Item No. **Report of the Head of Development Management and Building Control**

Address: 17 WOODSIDE ROAD NORTHWOOD

Development: Erection of a double storey side and part first floor rear extension with new front door and amendments to fenestration.

LBH Ref Nos: 29754/APP/2023/1806

Currently
proposed
front
elevation

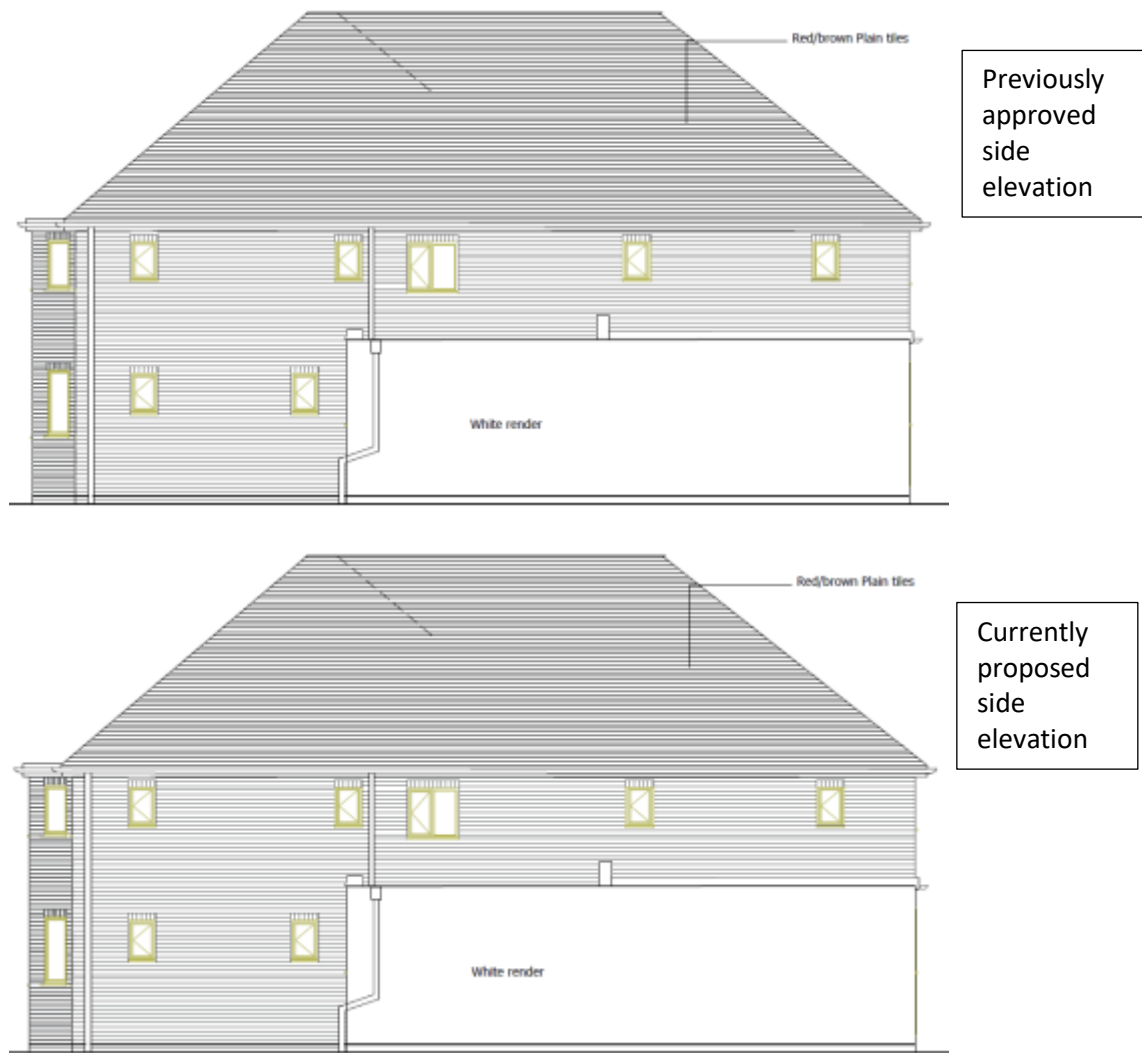
It is acknowledged that the physical siting and ground floor footprint of the proposed development would be almost identical to the scheme previously approved under planning permission ref: 29754/APP/2019/3994. However, the proposed crown roof profile would be excessive in size resulting in a top heavy massing and bulky upper part of the building, which would appear discordant relative to the original hipped roof profile on the host dwelling. In this regard, the resultant scale, size, bulk, massing and design of the proposed development would appear visually obtrusive and out of keeping with the other dwellings in the street scene. The proposal would also conflict with Policy DMHD 1 of the Local Plan, which resists large crown roofs on detached houses. By comparison to the approved scheme, the current proposal would represent a retrograde step in design quality.

The proposed development, by reason of its size, scale, massing and design (including its uncharacteristic crown roof profile with an excessive flat roof section) would fail to harmonise with the architectural composition of the original dwelling, appearing as a visually dominant, incongruous and bulky form of development which would be detrimental to the visual amenity of the street scene and the surrounding Gatehill Farm Estate Area of Special Local Character. The proposed development is therefore contrary to Policies BE1 and HE1 of the Hillingdon Local Plan: Part One - Strategic Policies (November 2012), Policies DMHB 1, DMHB 5, DMHB 11, DMHB 12 and DMHD 1 of the Hillingdon Local Plan: Part Two - Development Management Policies (2020), Policies HC1, D3 and D4 of the London Plan (2021) and the National Planning Policy Framework (2021).
